From: Laura Gibbons <Laura.Gibbons@arun.gov.uk>
Sent: 19 October 2021 08:57
To: Planning.Responses <Planning.Responses@arun.gov.uk>
Cc: David Easton <David.Easton@arun.gov.uk>
Subject: RE: Planning Consultation on: Y/127/21/RES

Thank you for consulting us on this reserved matters application, we have the following comments regarding surface water drainage.

Application No: Y/127/21/RES

Description of Works: Approval of reserved matters (appearance, landscaping, layout and scale) following the grant of Y/91/17/OUT for 250 No dwellings with associated parking, road/footway/cycleway provision, open space, landscaping, surface

BASIN 1 SECTION A-A
SCALE: H 1:500,V 1:100. DATUM: 2.000

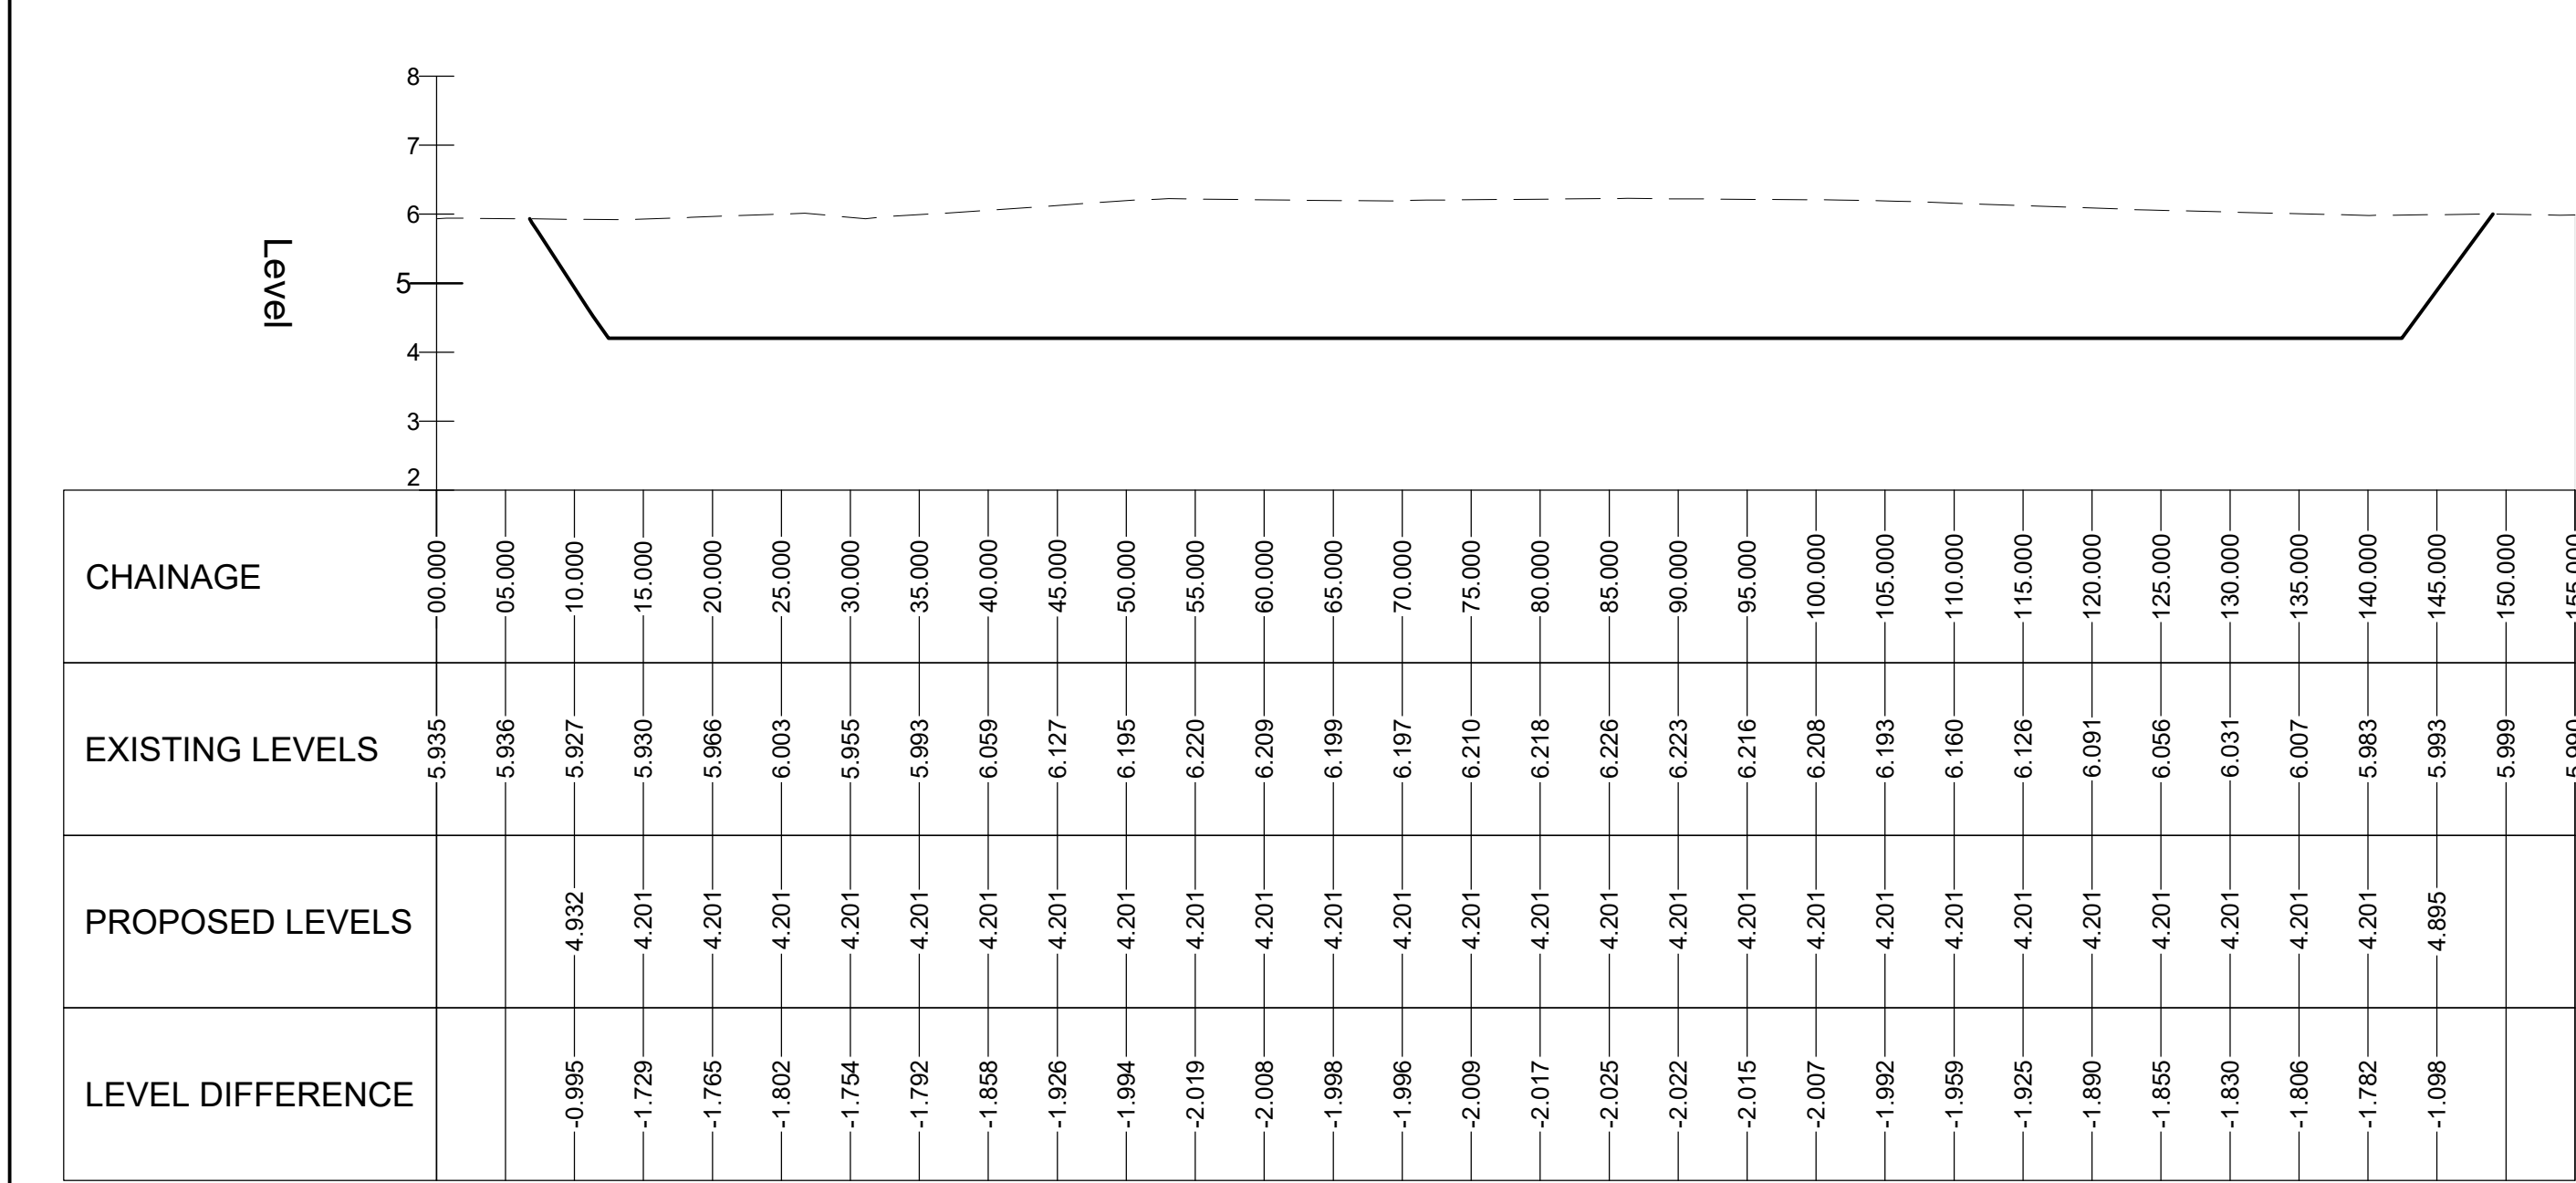
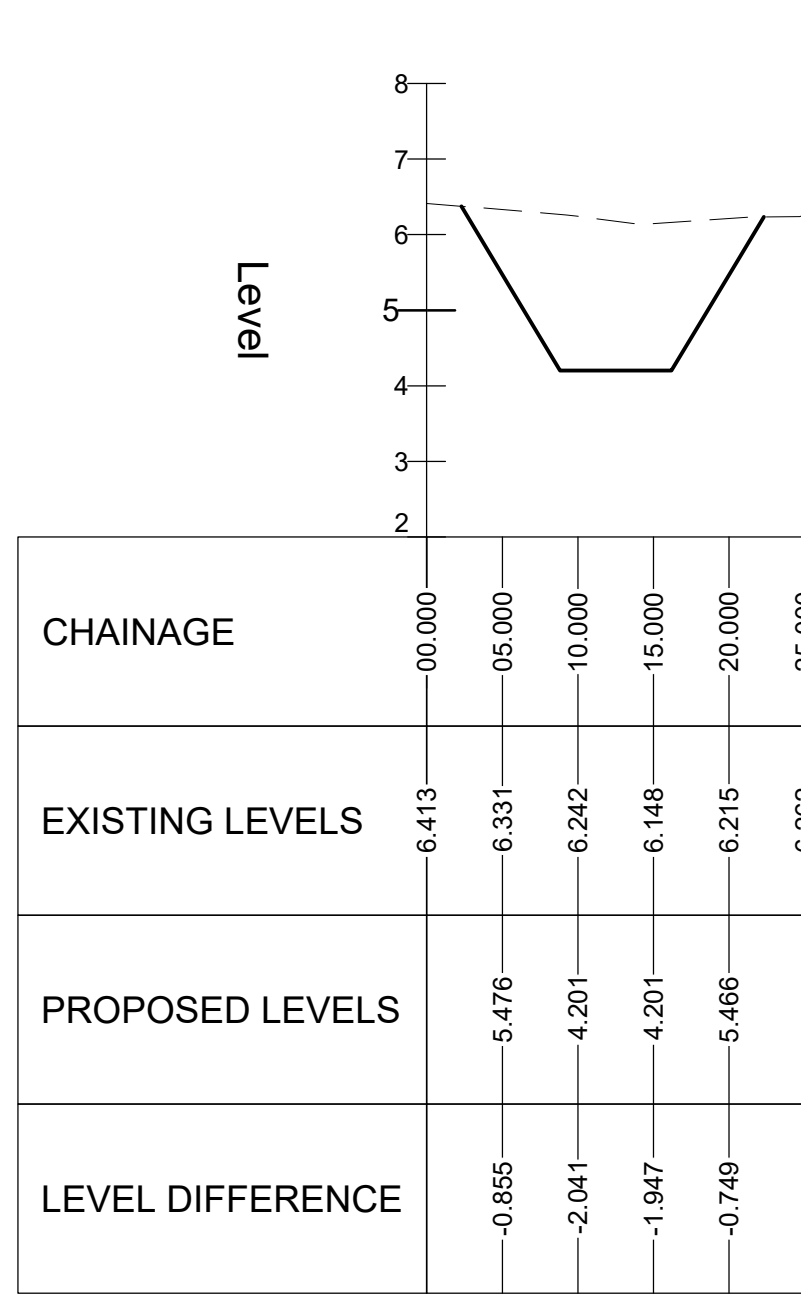
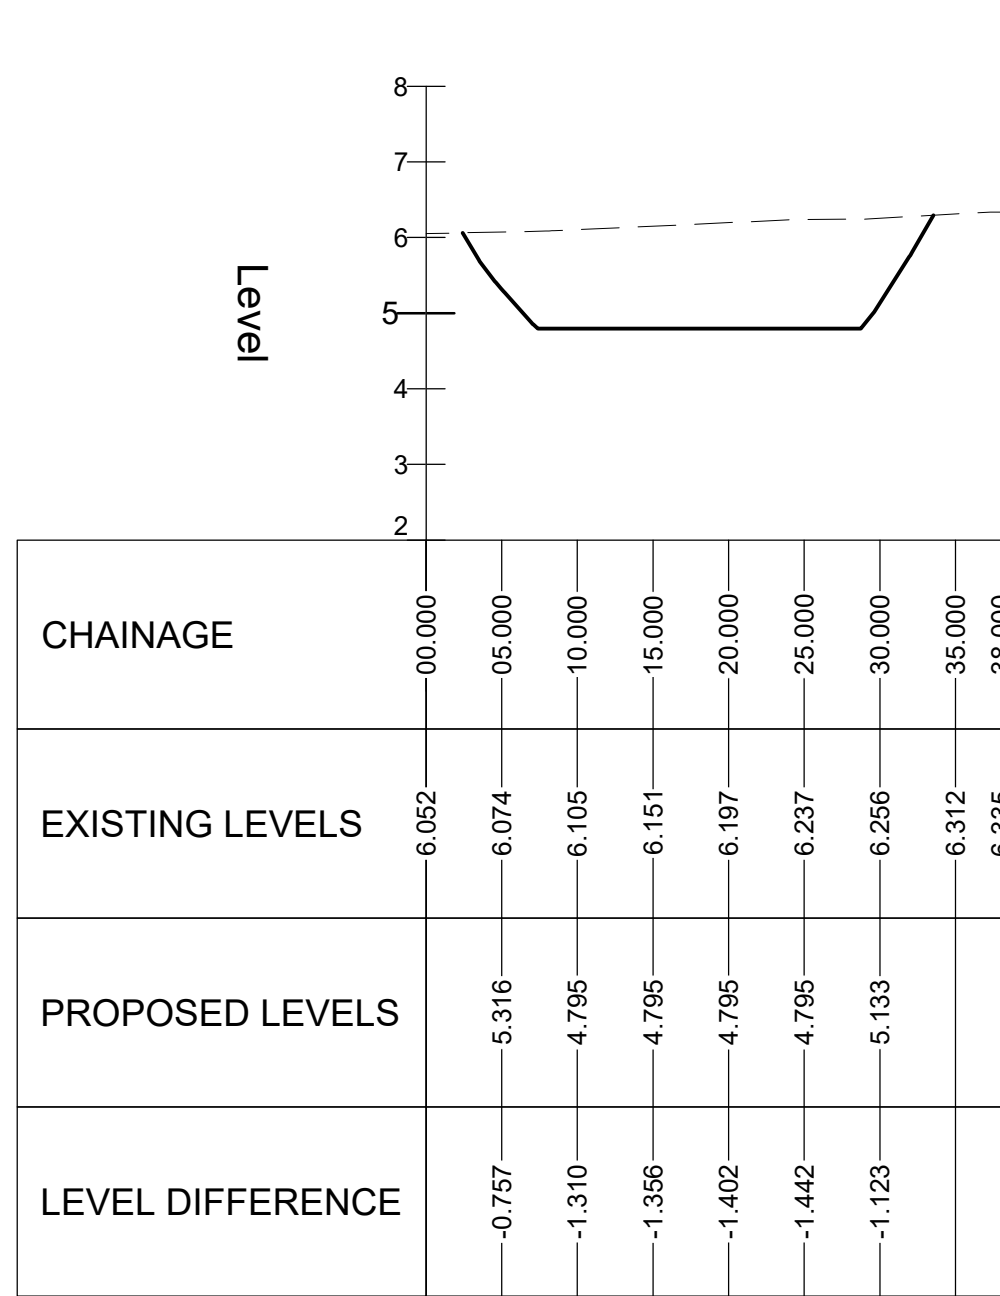
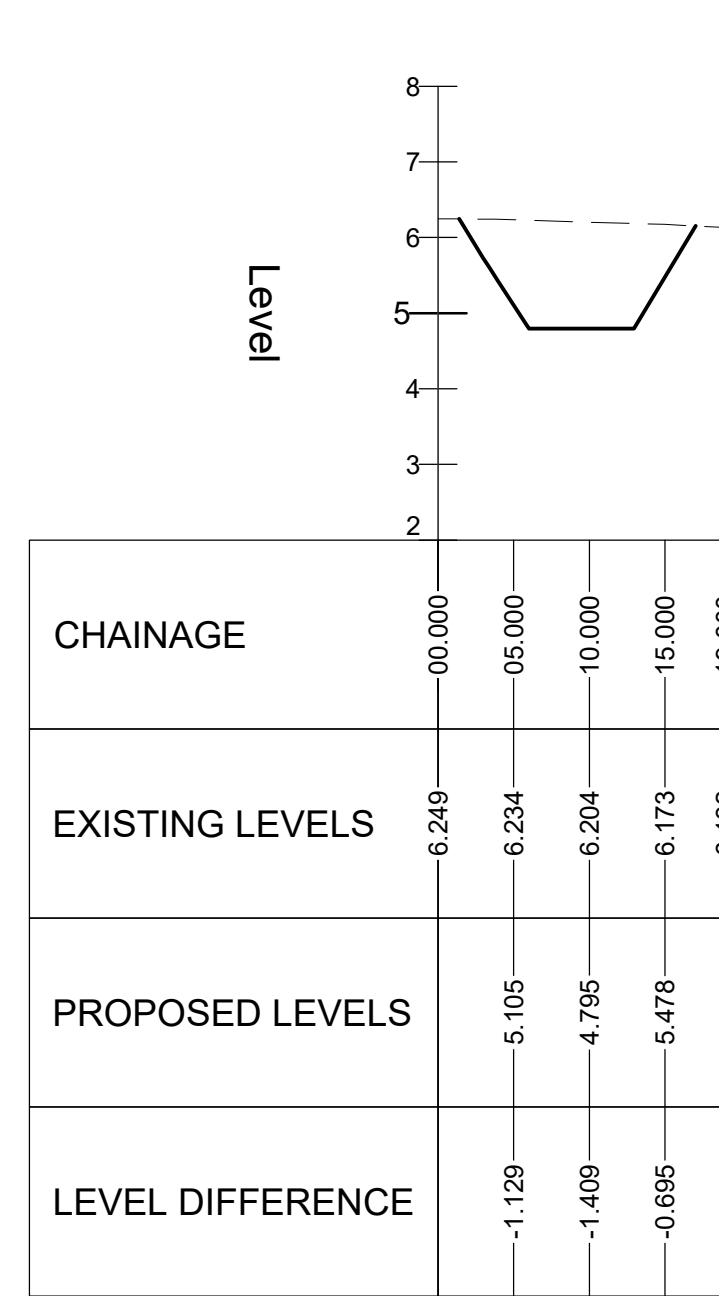
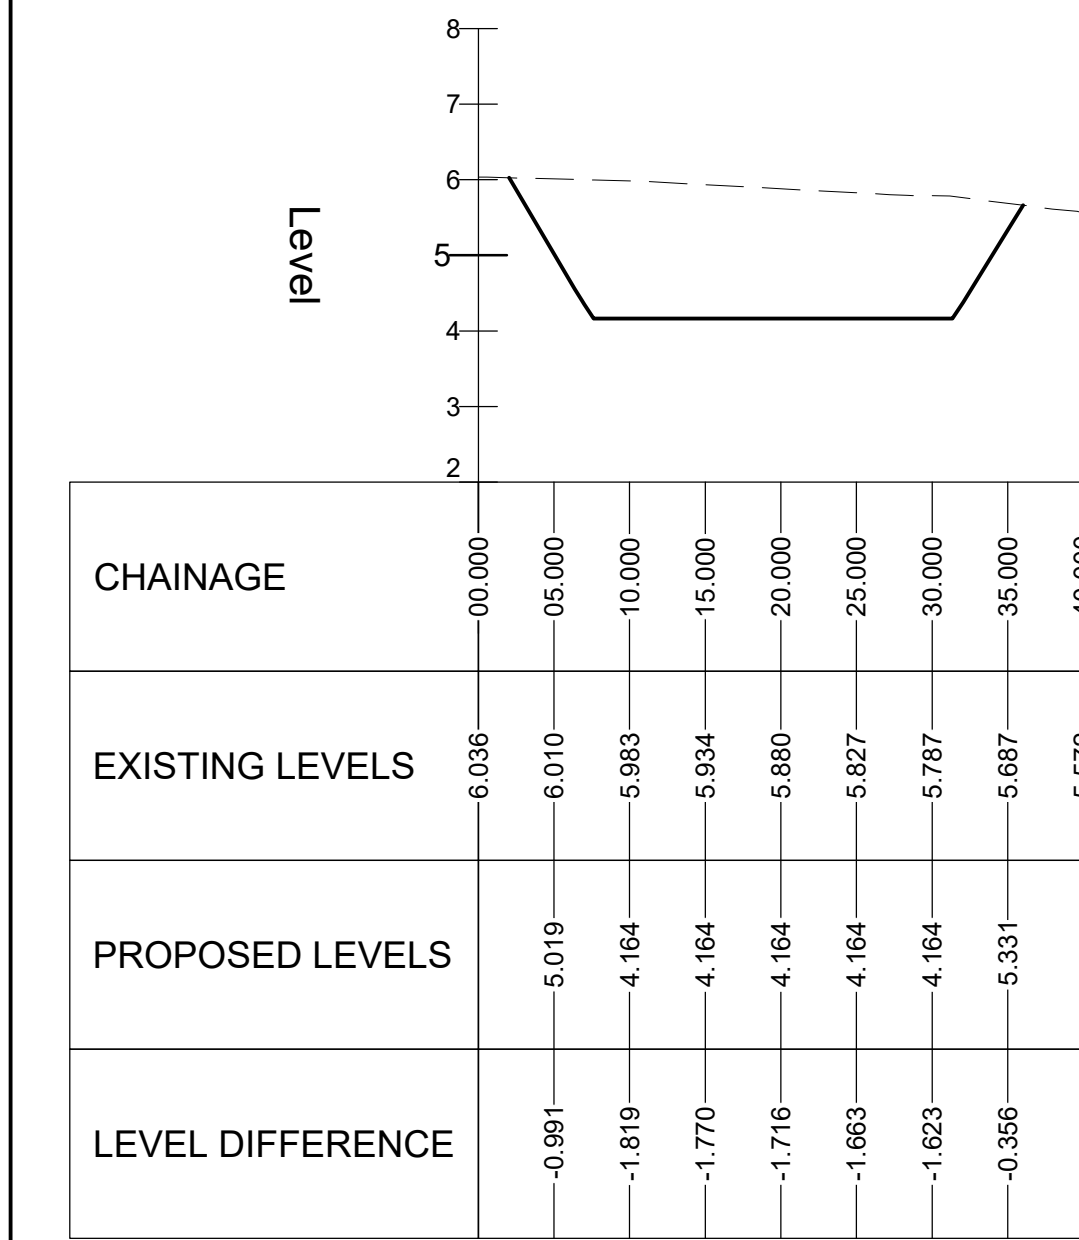
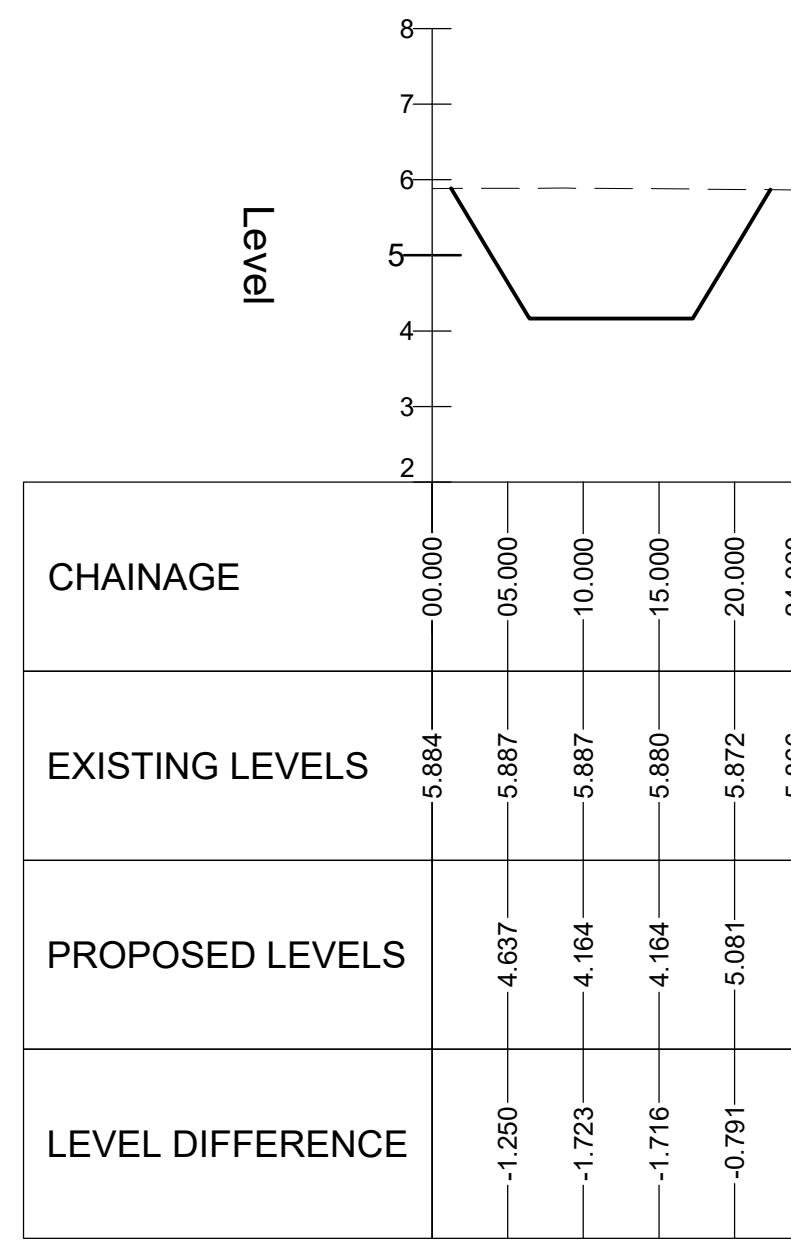
The landscaping proposals submitted with this reserved matters application include proposals for a number of trees to be located within close proximity of the attenuation features. Please can the applicant submit plans which show tree root potential areas. It should be demonstrated that there is no conflict between future tree roots and surface water drainage features.

The applicant should also supply a buffer plan which shows 3m clear buffer between top of bank of watercourses and proposed trees, fences, walls, buildings, attenuation features, etc.
